# SPR EA1N and EA2 PROJECTS

## DEADLINE 4 - COMMENTS ON APPLICANTS DEADLINE 3 SUBMISSIONS

Interested Party: SASES PINS Refs: 20024106 & 20024110

Date: 13 January 2021

Plate 3.1: HVAC 190x190m substation model for 800MW

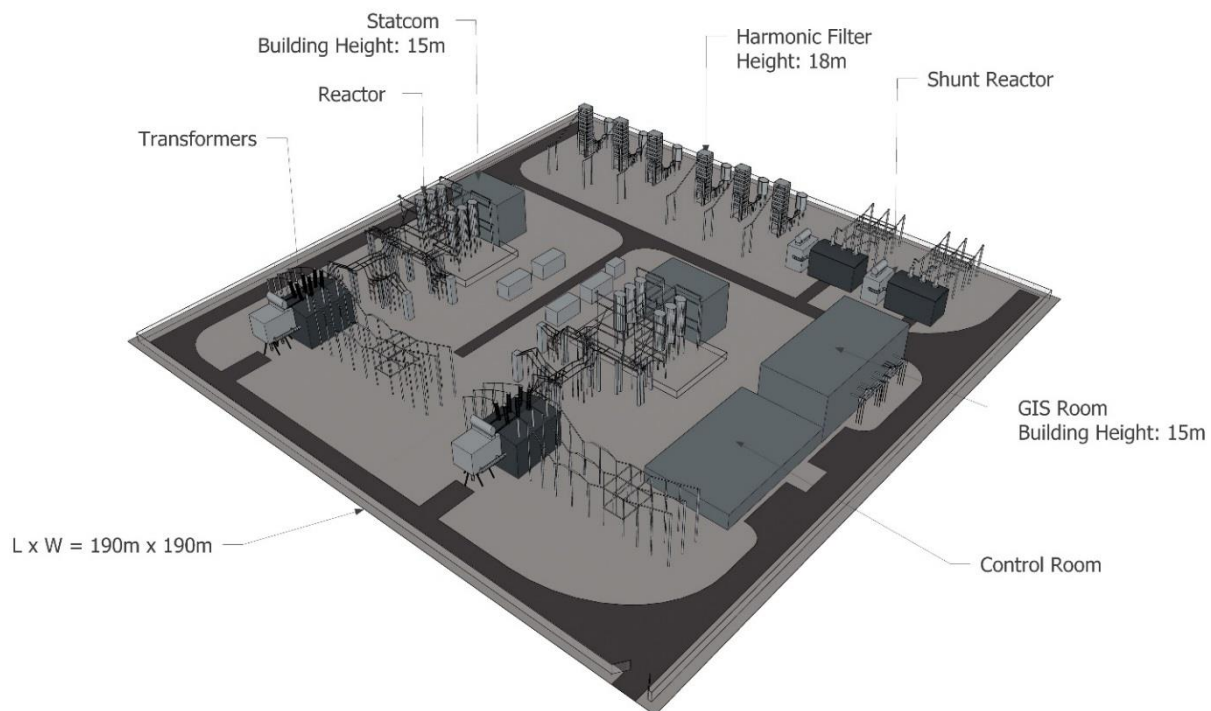
2. The proposed substation area of **3.23ha** is substantially greater than the benchmark **2.1ha** for an 800MW HVAC substation documented by NGESO in their report forming part of the recent BEIS Offshore Transmission Network Review (Table 2-24 on page 38 of <https://www.nationalgrideso.com/document/182936/download>). The increased size needs to be fully justified.

4. The 3D schematic (Plate 5.2 of [REP3-057]) and revised OLMP (Figure 3 of [REP3-030]) both show large areas of vacant substation area between the reduced sized electrical equipment. The Applicants are asked to justify why the equipment spacing is so great and why there is no reduction in the 190m dimension. It should be noticed that the orientation of the 3D schematic in plate 5.2 is different from the orientation of both the eastern and western substation shown in the OLMP.

6. The Applicants are asked to confirm that the revised design is based on the optimum use of the latest 'compact' GIS switchgear equipment, as a yet greater height reduction would be highly desirable.

7. The reference Rampion wind farm substation design (Figure 3 on page 165 of [REP1-227]) appears to use multiple smaller Harmonic Filters in order to produce an overall reduction in height. Has this option been explored?
